15th December 2020

RE: ASPECT Industrial Estate SSD-10448 – Submission for Public Exhibition

TYPICAL SECTION - TEMPORARY TURNING HEAD

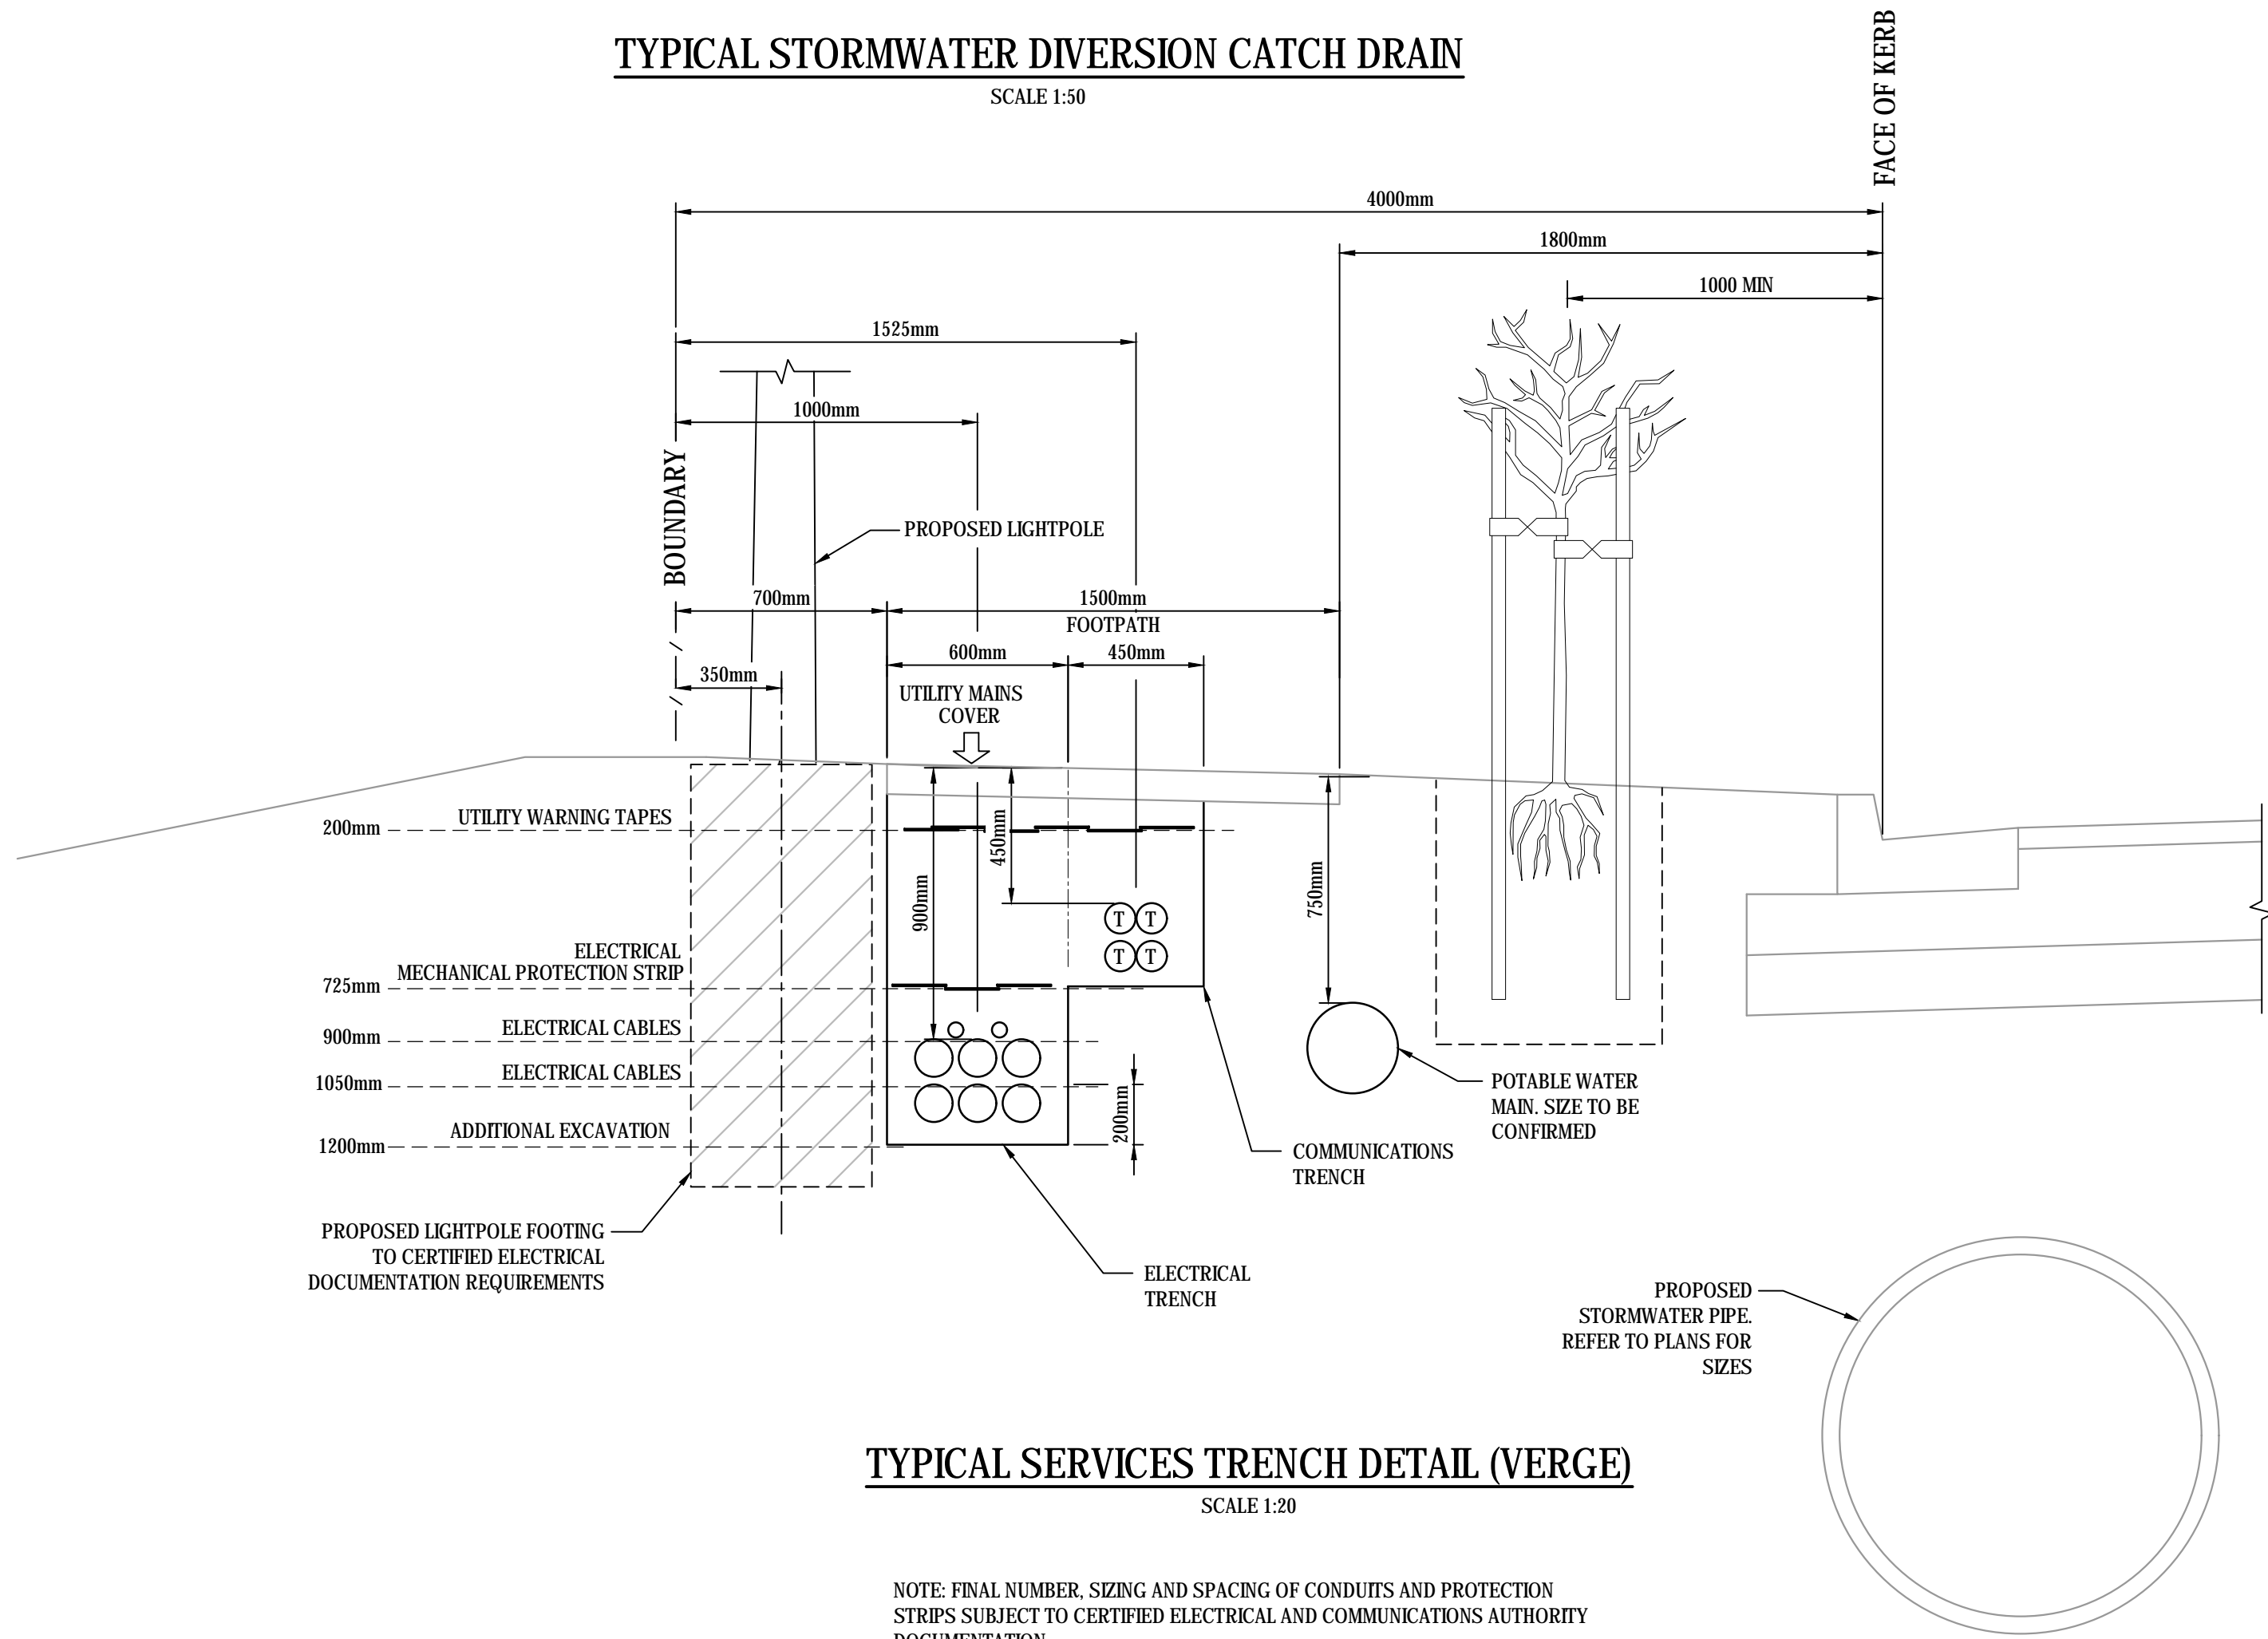
SSDA-10448 only allows for the construction of a portion of Access Road 1 with a temporary cul-de-sac restricting access to adjoining properties and the continuation of the Precinct Road Network.

Project	ASPECT INDUSTRIAL ESTATE MAMRE ROAD, KEMPS CREEK STAGE 1
	ROAD 01 LONGITUDINAL SECTION SHEET 1

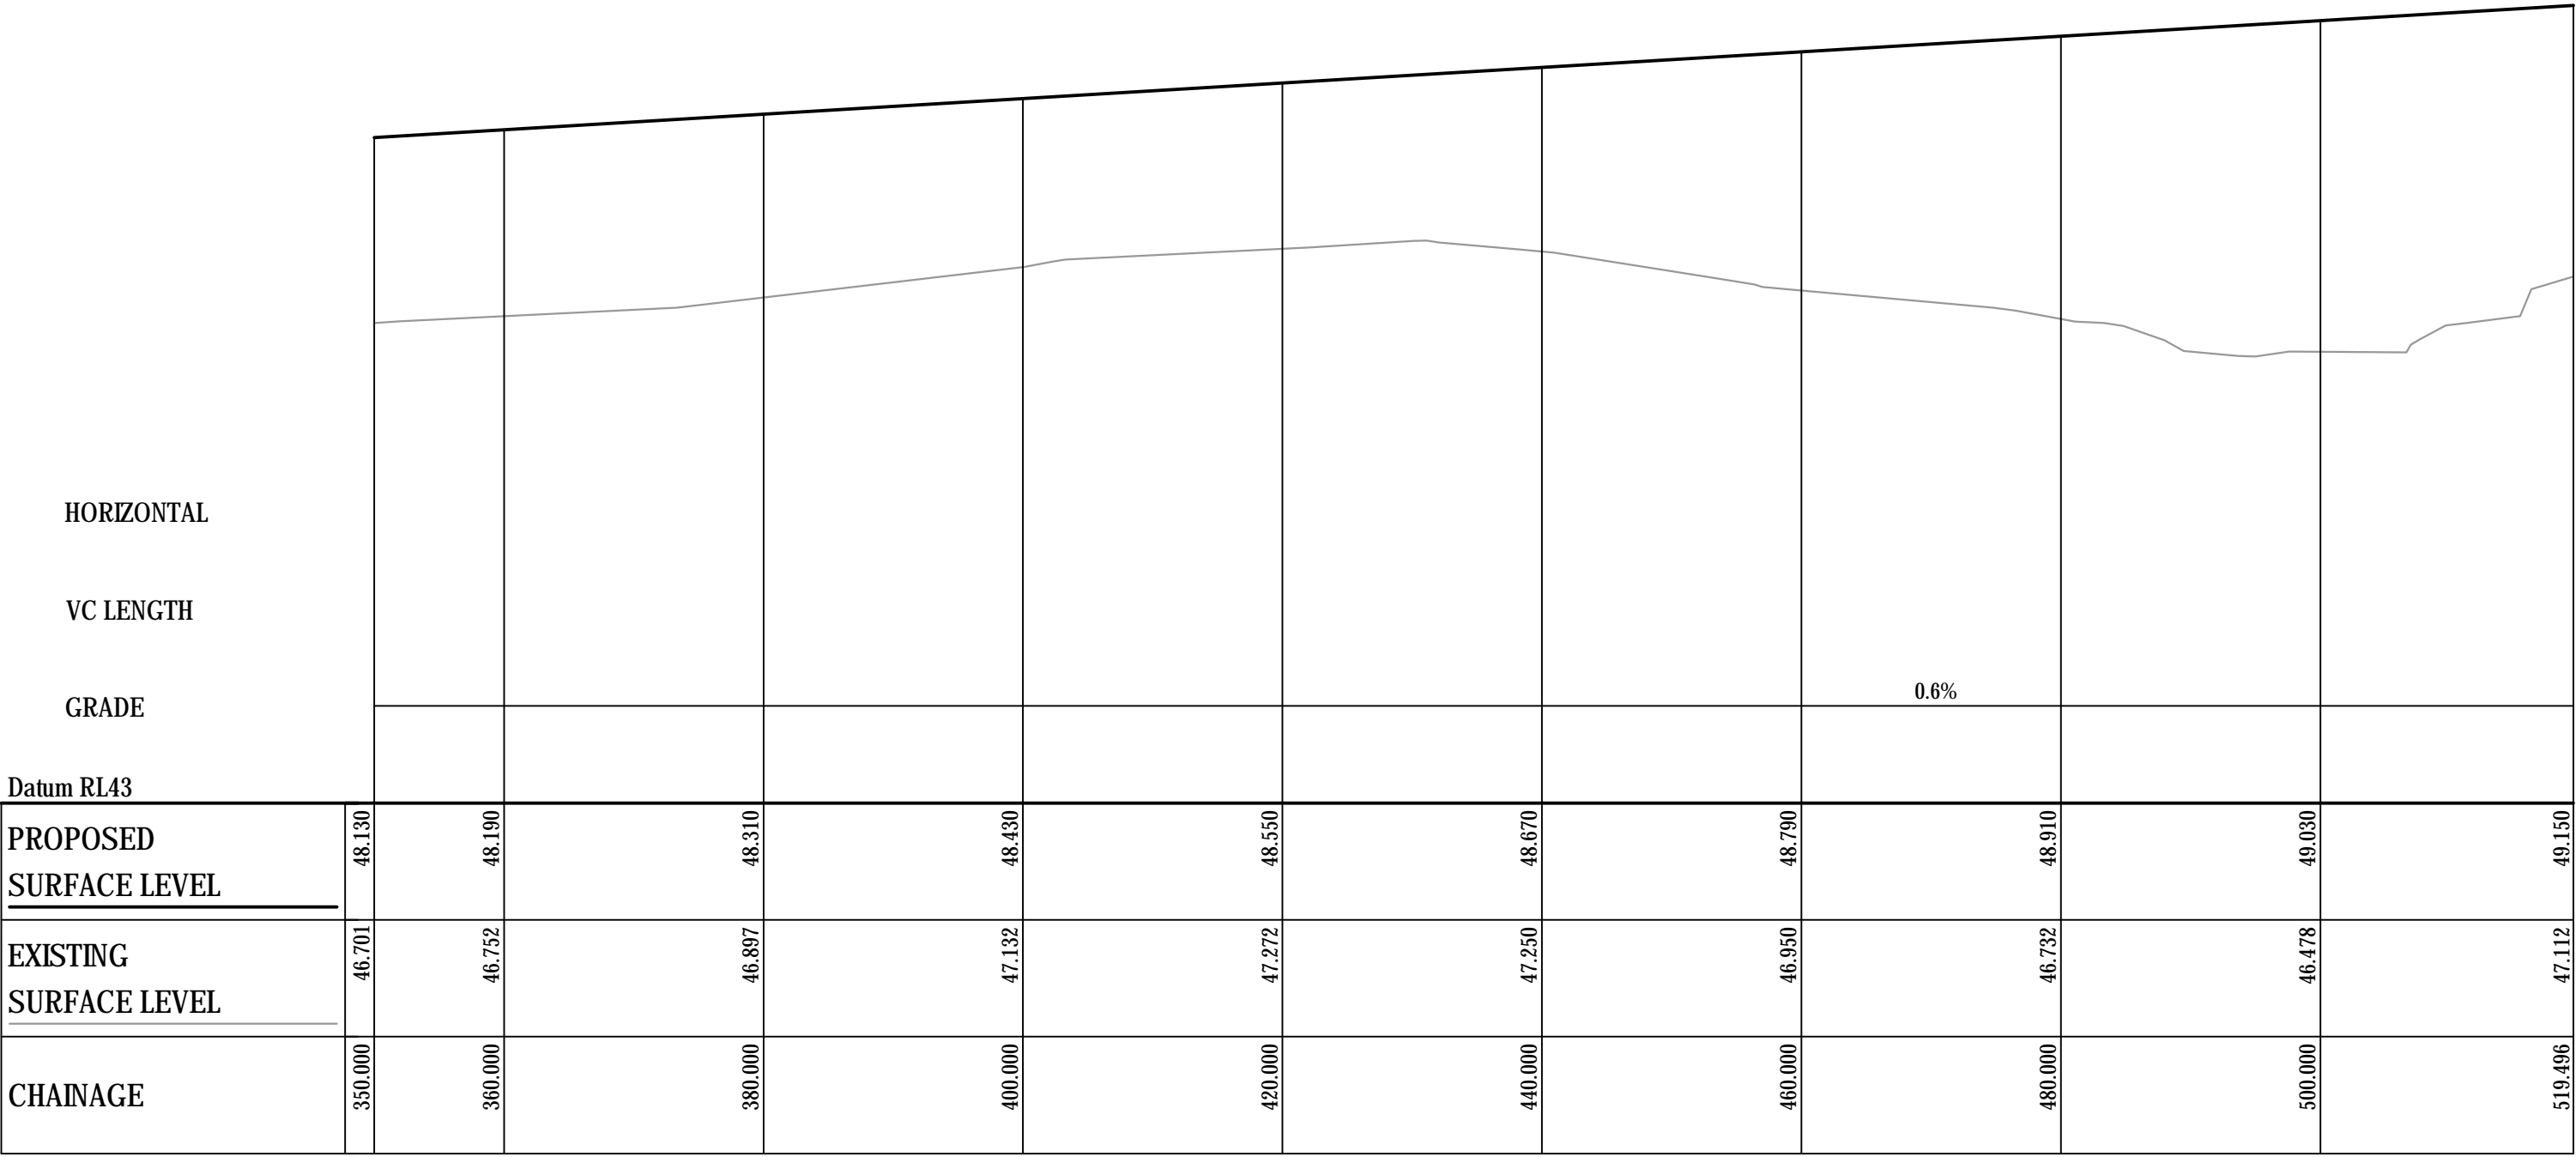
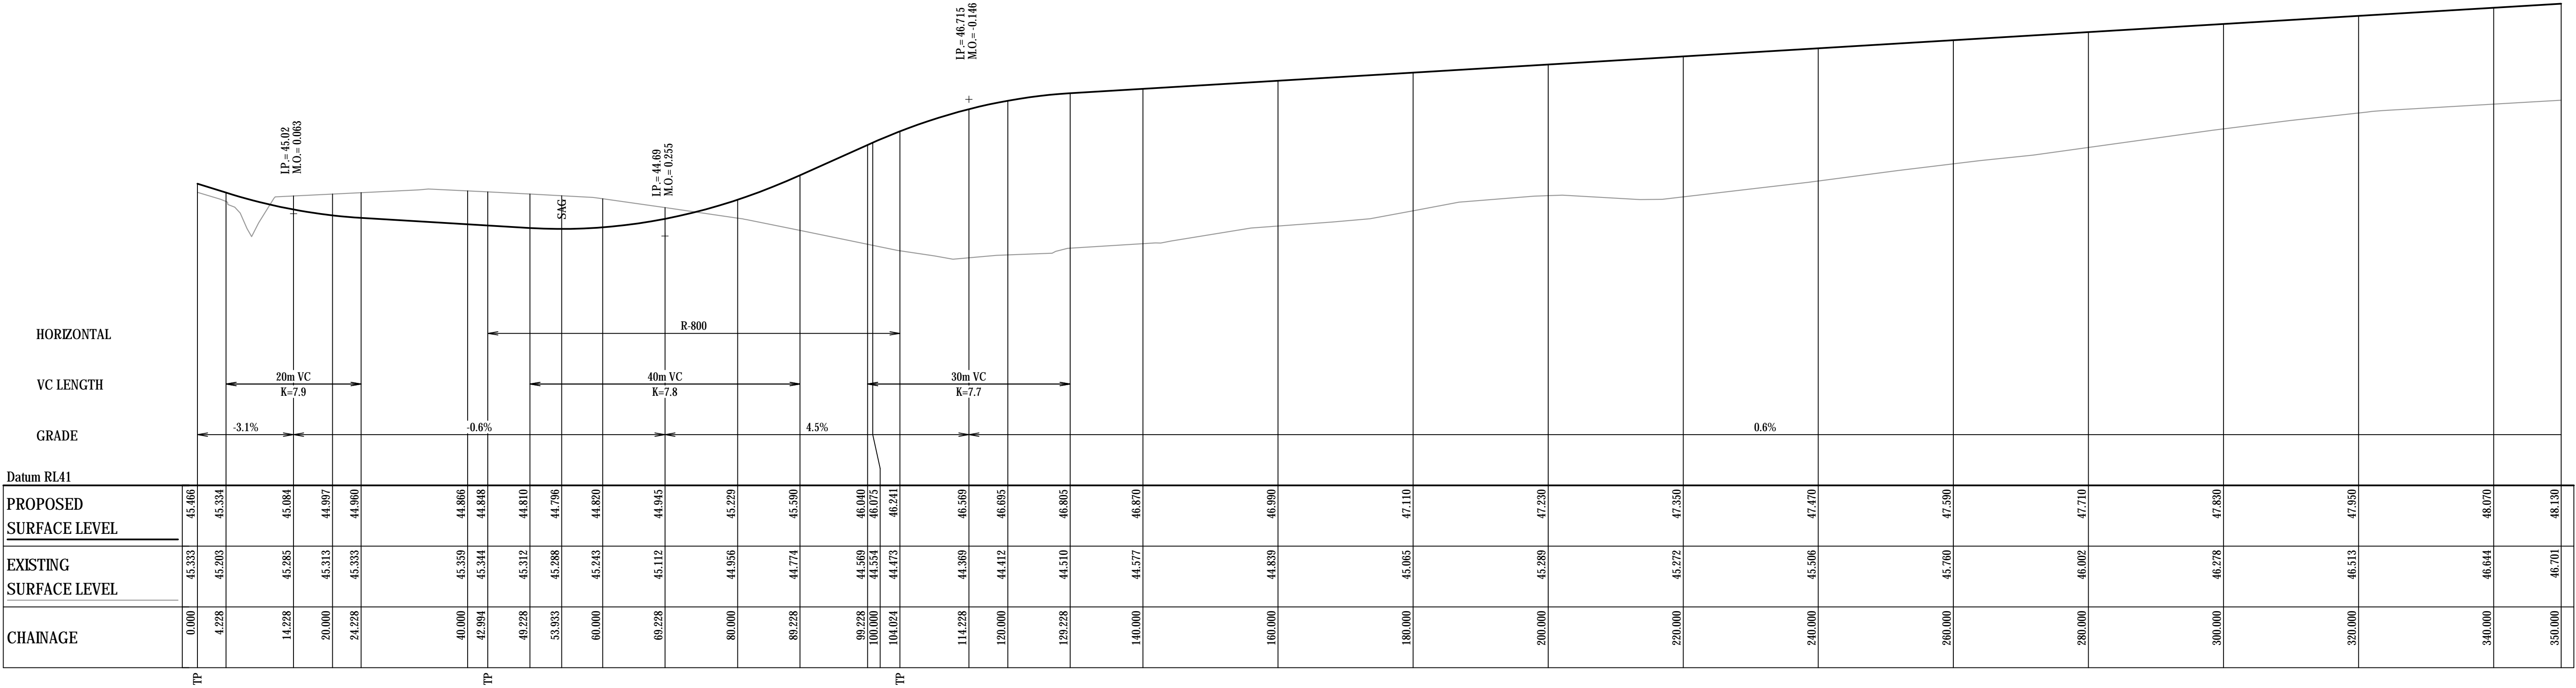
Access Road 1 as depicted in SSDA-10448 and shown in Appendix 2 represents the key “higher order road” heading east from this intersection that will provide connectivity to over 200 hectares of land along Mamre Road and will be a key part of the Mamre Road Precinct Road Network, providing access to adjoining lots and permeability throughout the precinct.

Altis request that Access Road 1 is extended to the eastern and southern boundary of the site (refer to Appendix 3) as part of the applicant's stage one infrastructure works to enable connectivity to adjoining sites immediately and welcome the opportunity to work with Mirvac to facilitate this.
